Yakima River CG PH Comments

From: Holly Myers, Environmental Health Supervisor

Date: March 3, 2016

RE: CU-15-00002 Short Plat, Conditional Use

YAKIMA RIVER SHORT PLAT - SP 15-XXXXX
 A PORTION OF THE NORTH 1/2 OF SECTION 4,
 TOWNSHIP 19 NORTH, RANGE 16 EAST, W.M.,
 KITTITAS COUNTY, WASHINGTON

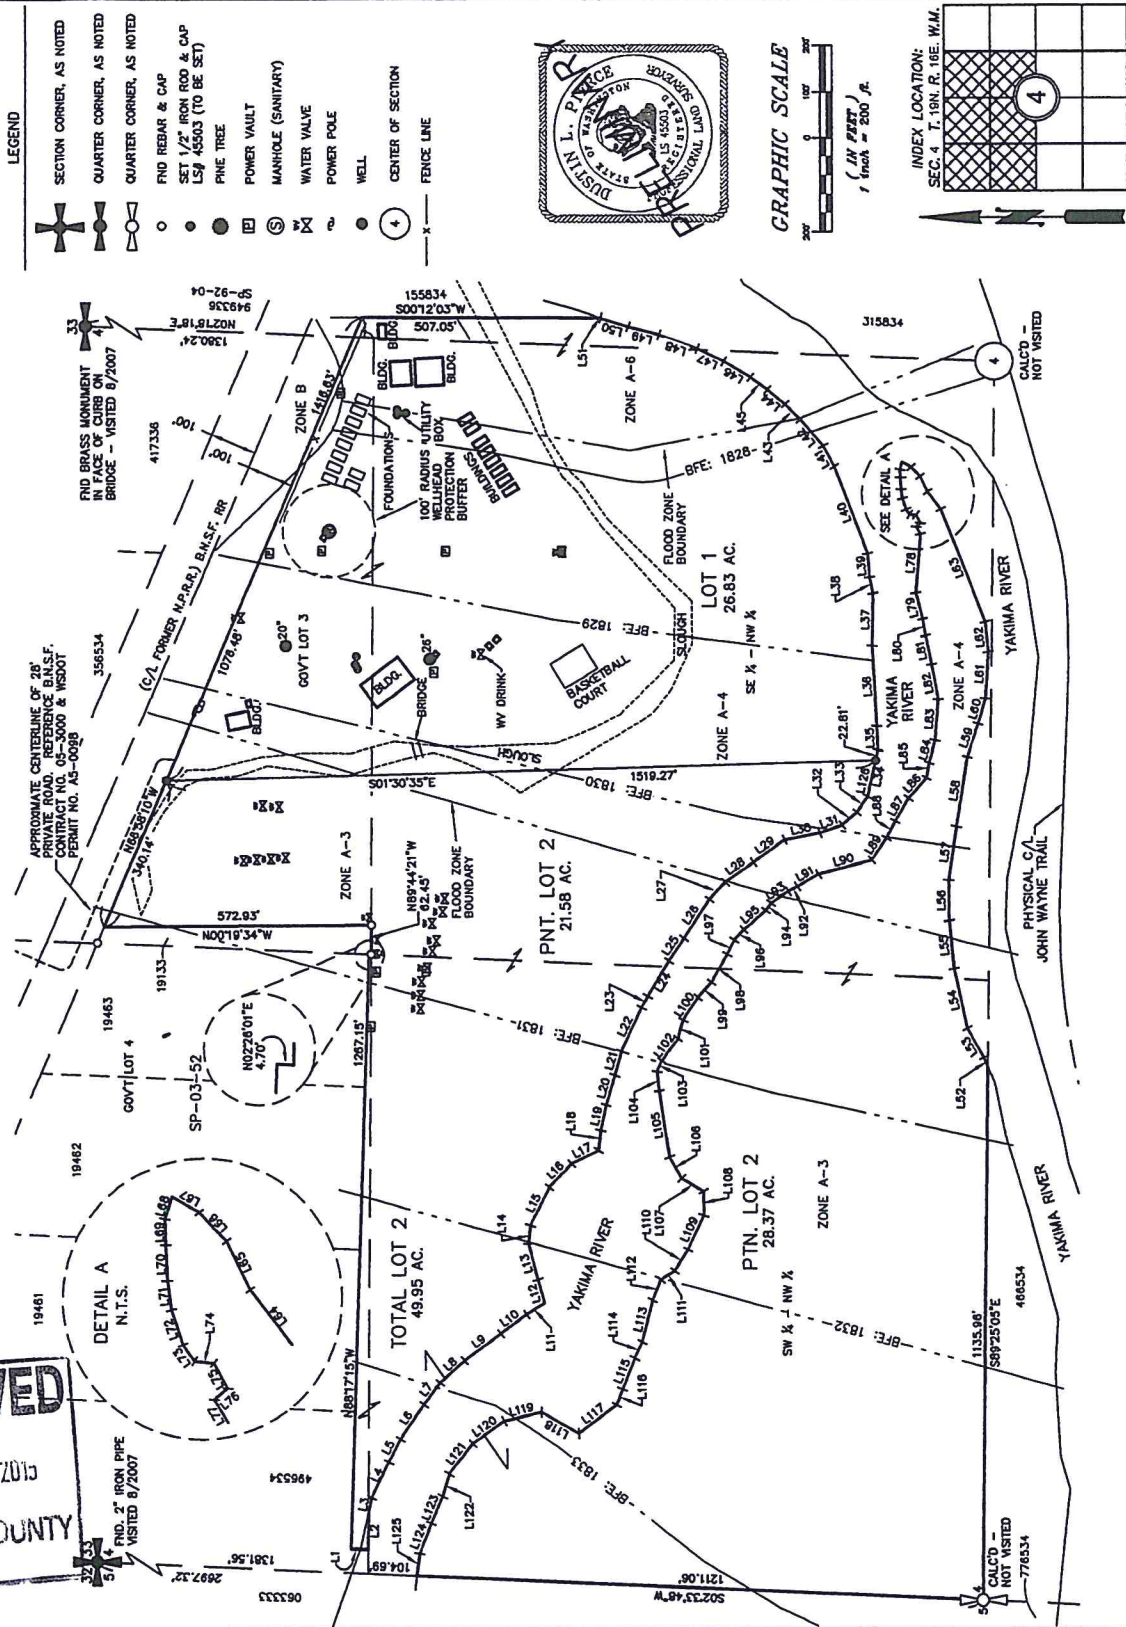
Identify Group A Water System on final plat

Use correct plat dedication as per KCC 16.24.210

Map must include existing septic systems with respect to proposed property lines.
